# Prelim Plan V\_4.pdf Markup Summary

**Subject:** Text Box  
**Page Index:** 2  
**Date:** 3/26/2019 2:11:10 PM  
**Author:** dsdrice  
**Color:** ■  
**Layer:**  
**Space:**  
**Page Label:** [1] Plan

COVER

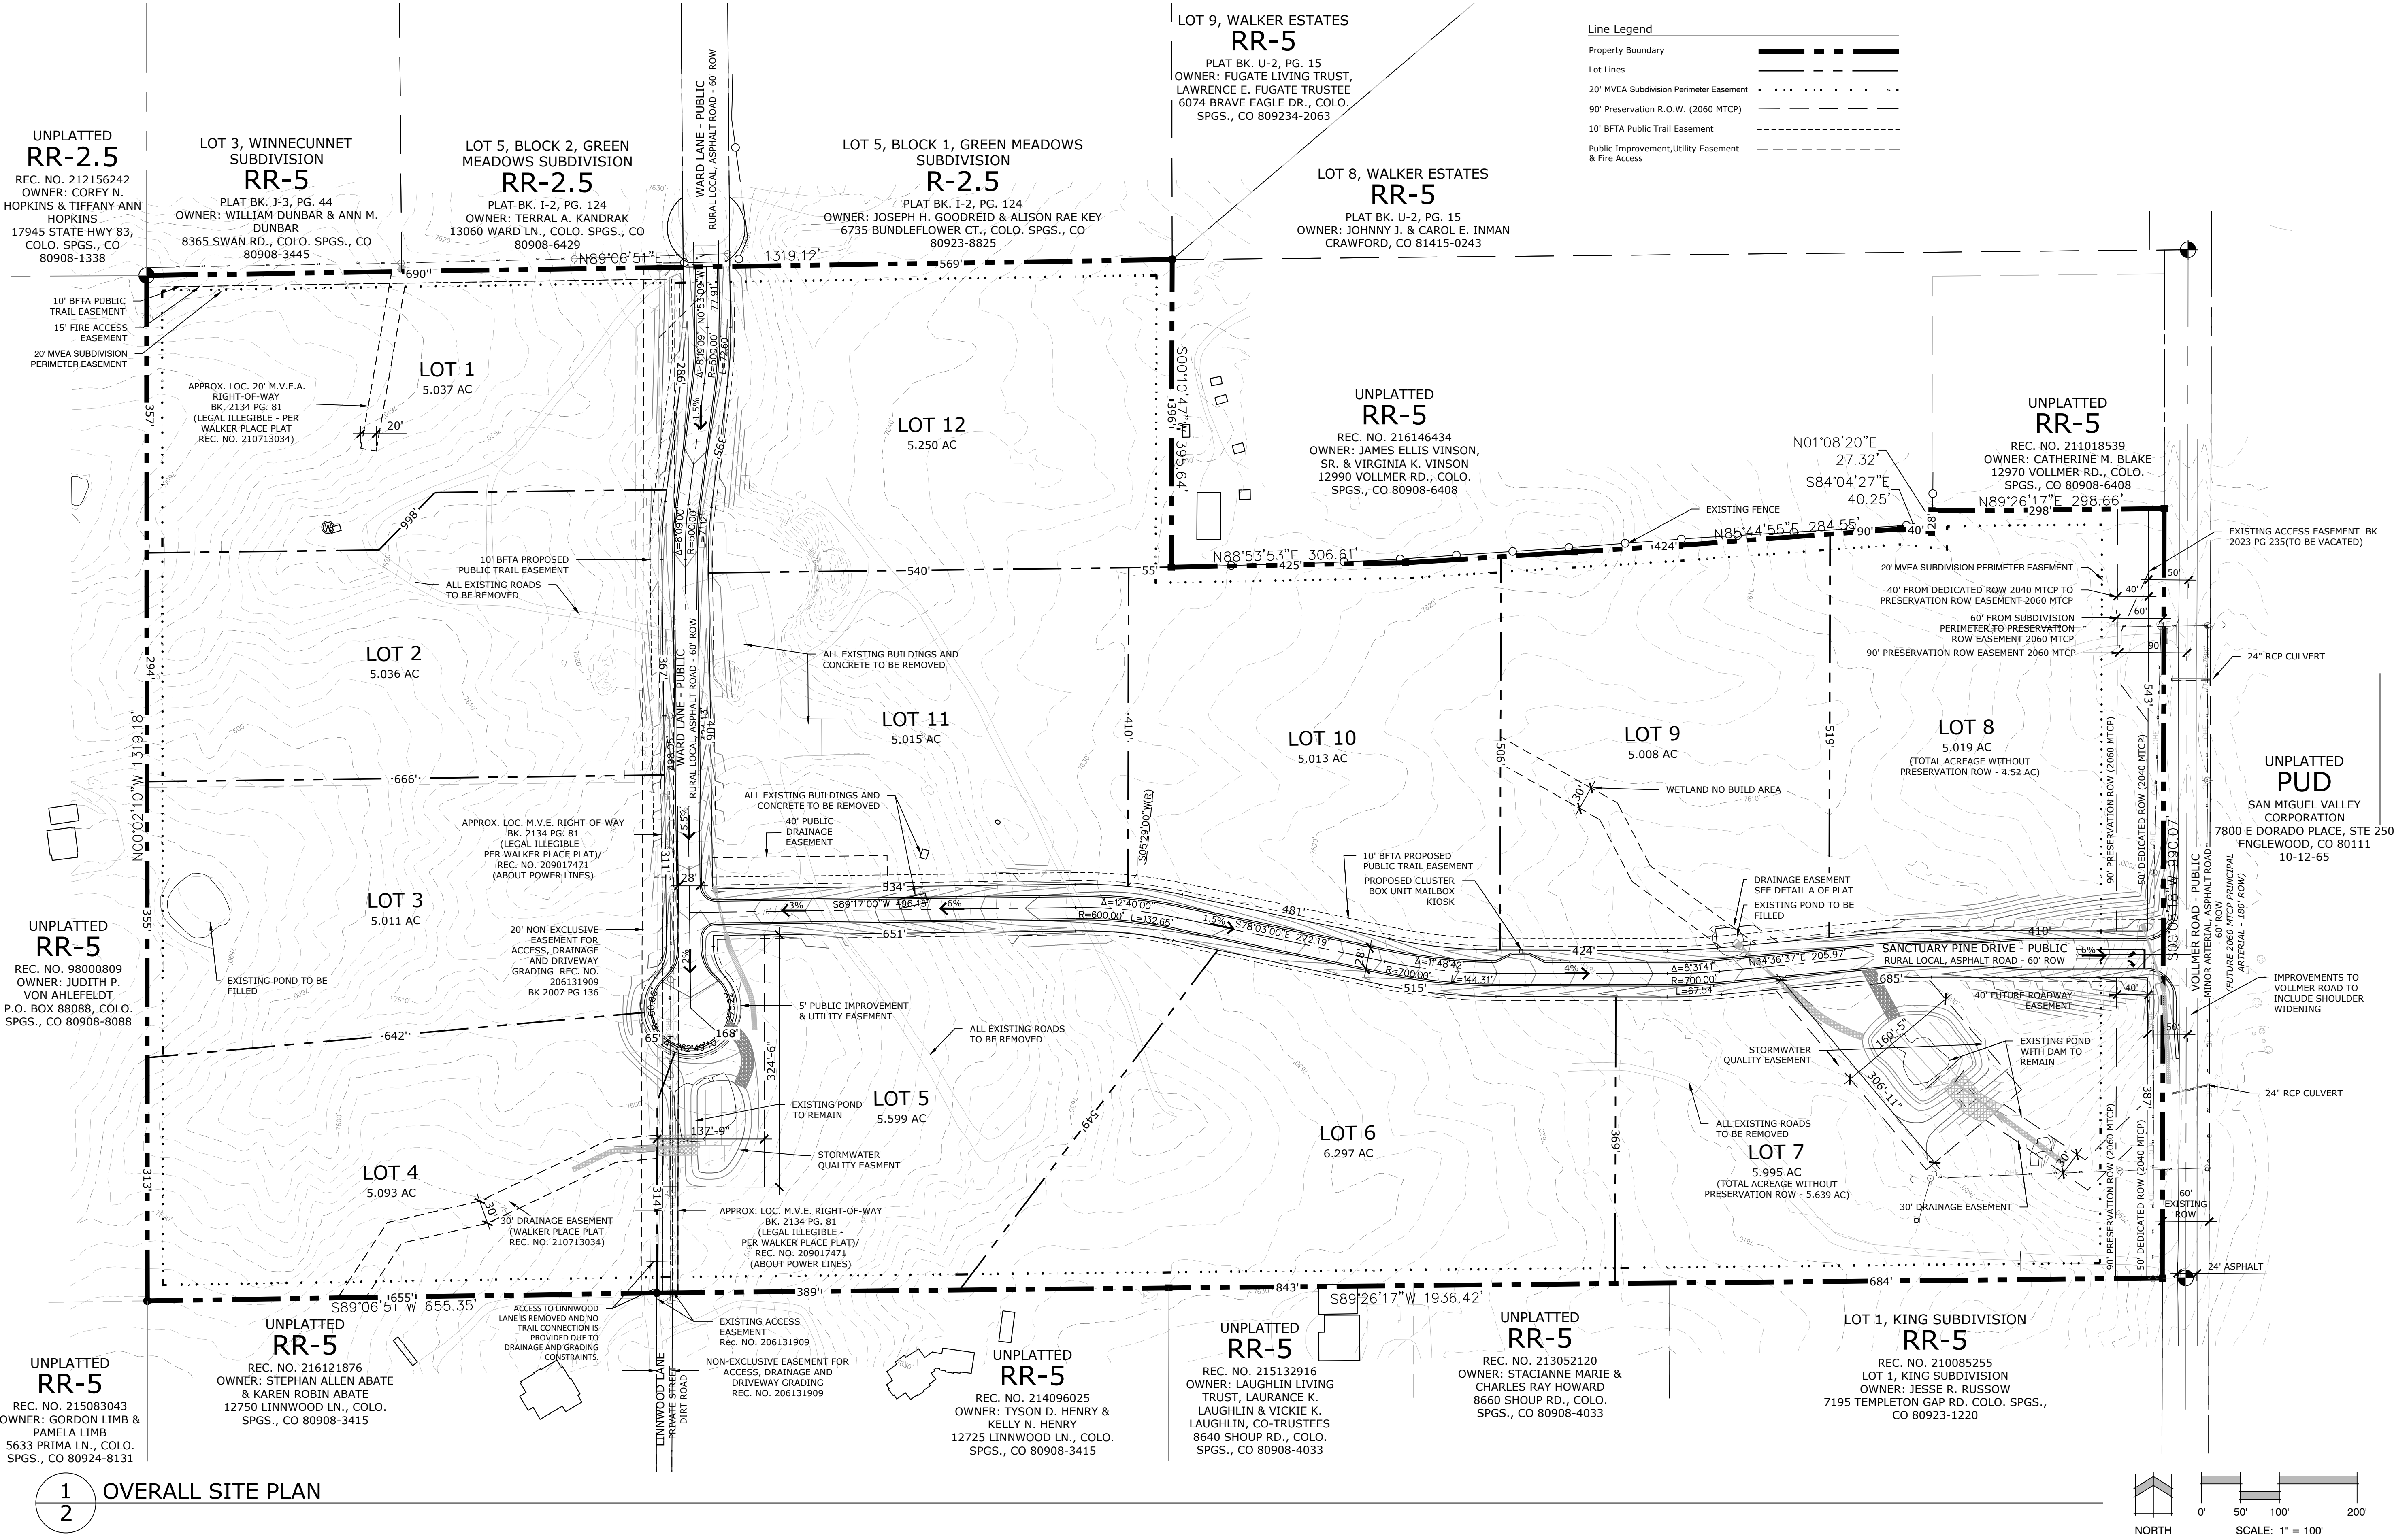
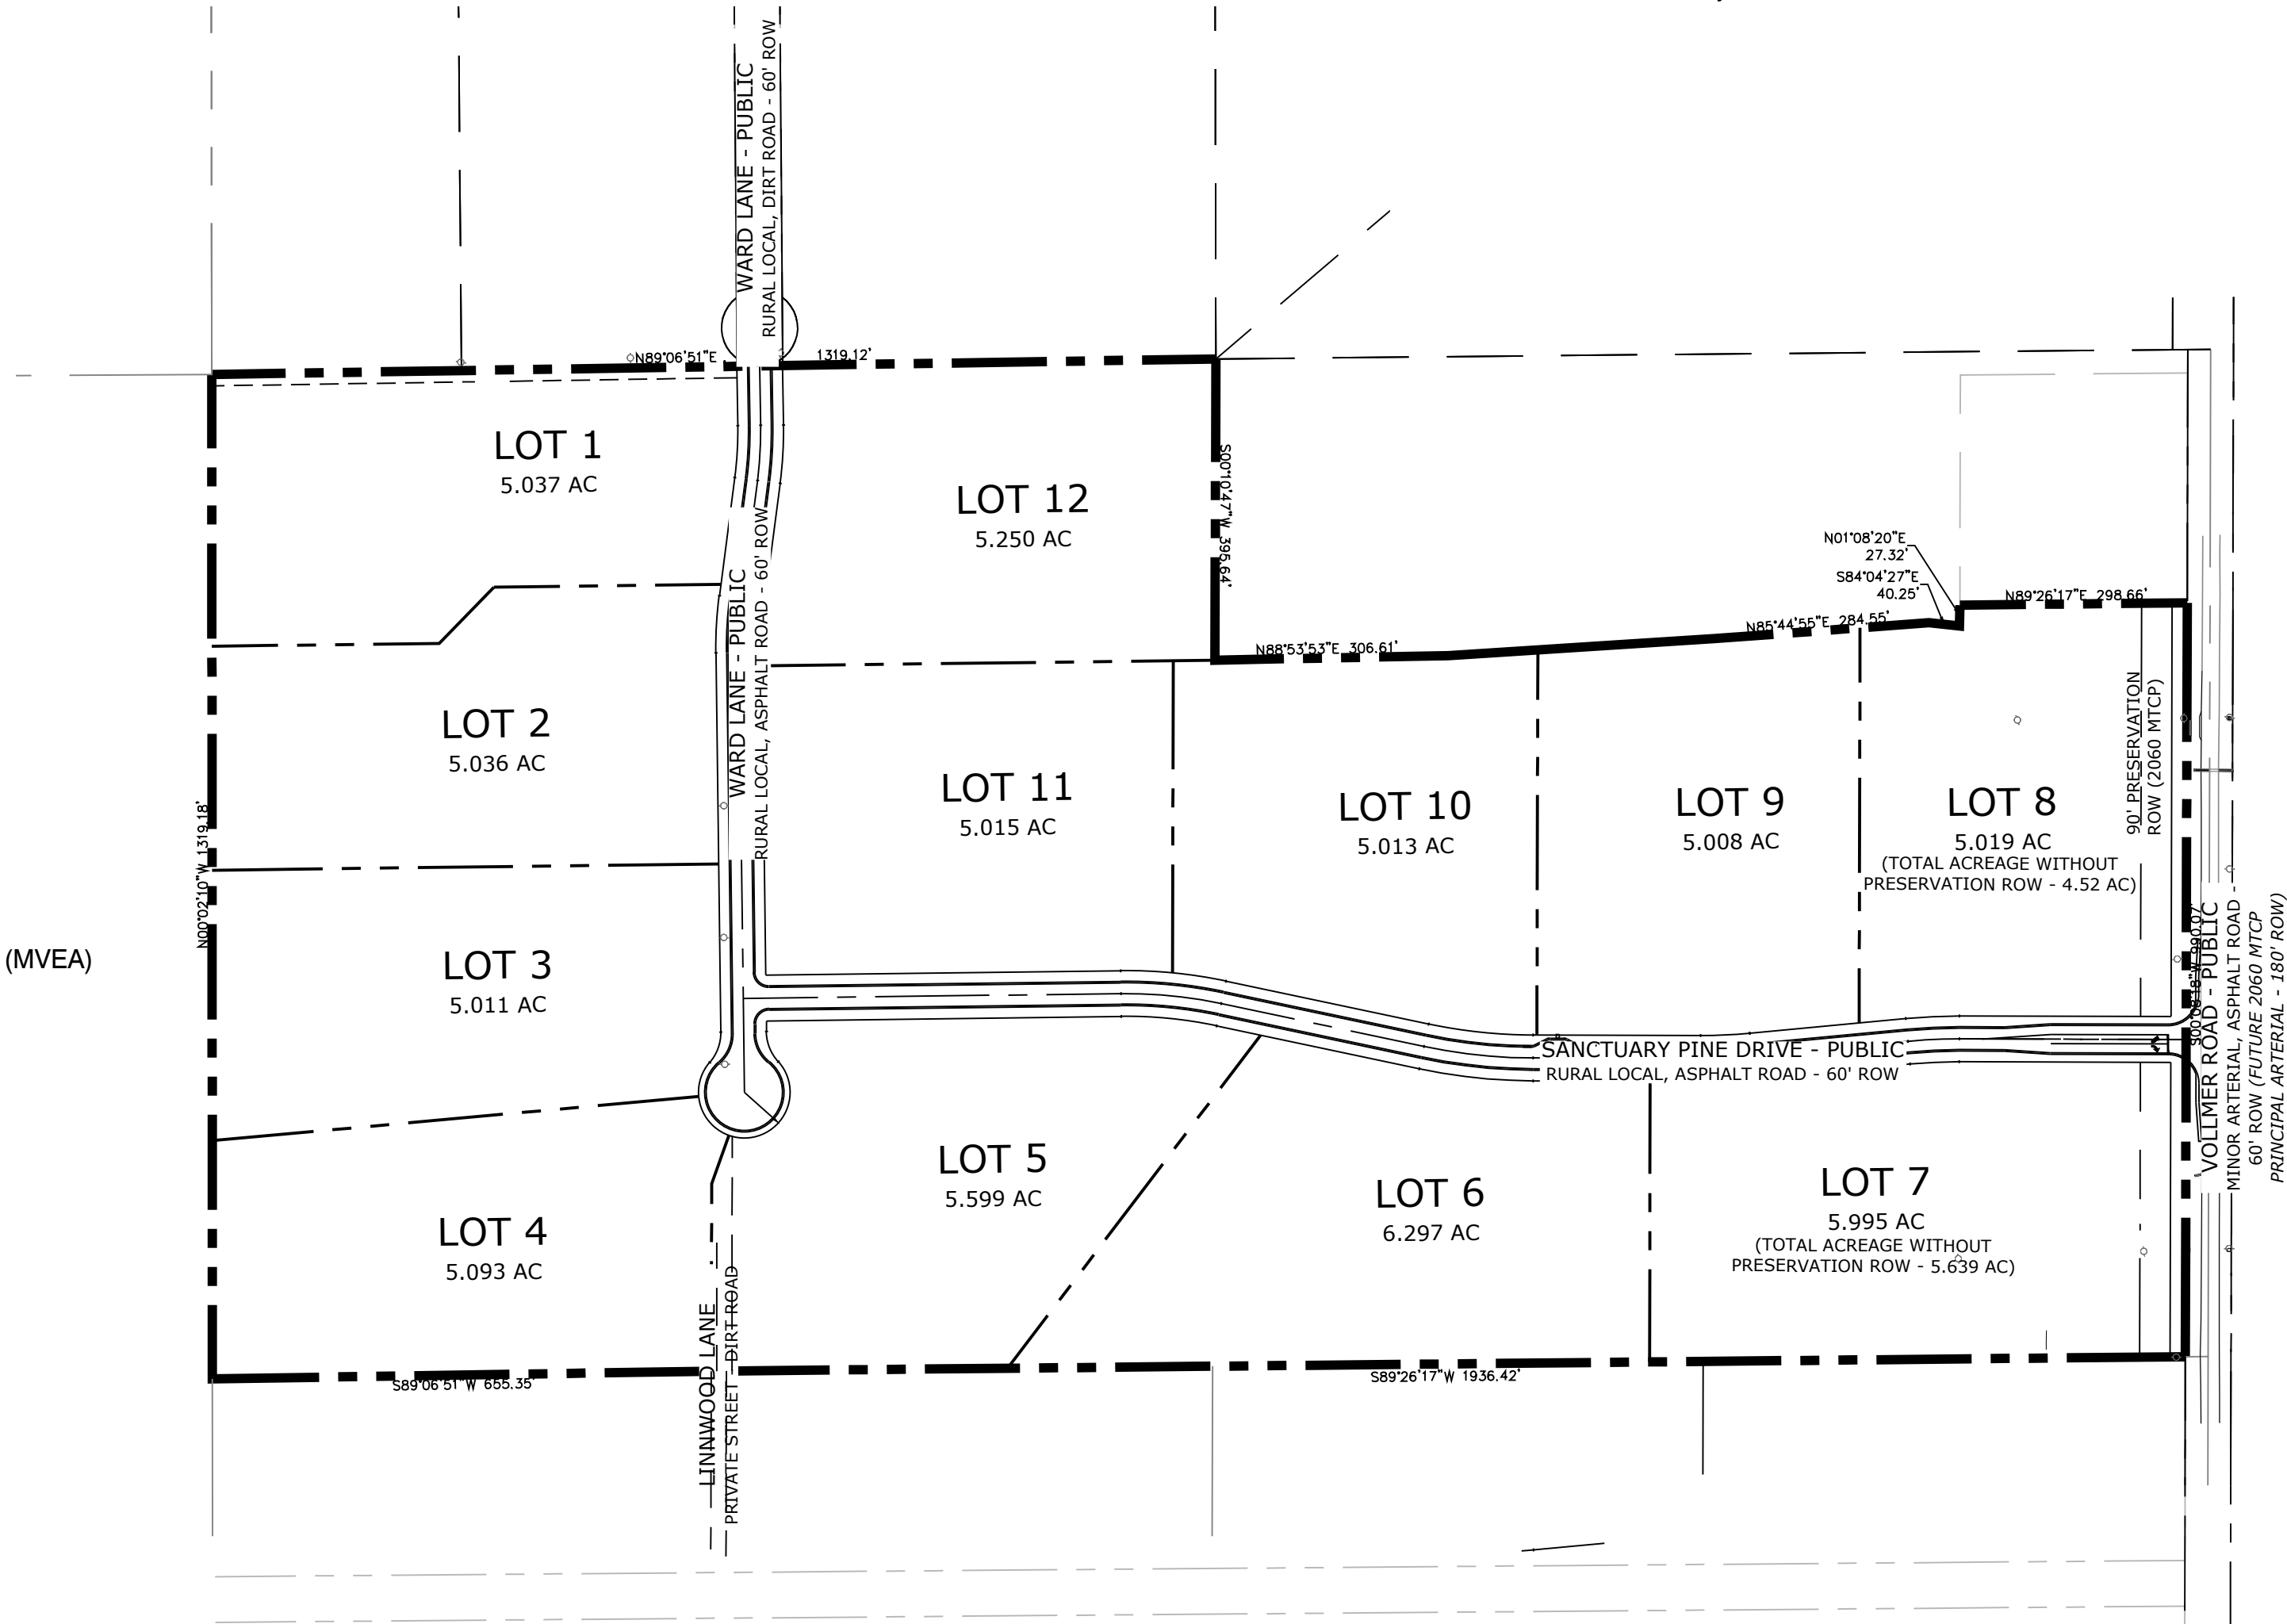
Label approximate road grades. (Unresolved from comment letter.)

Verify

Verify
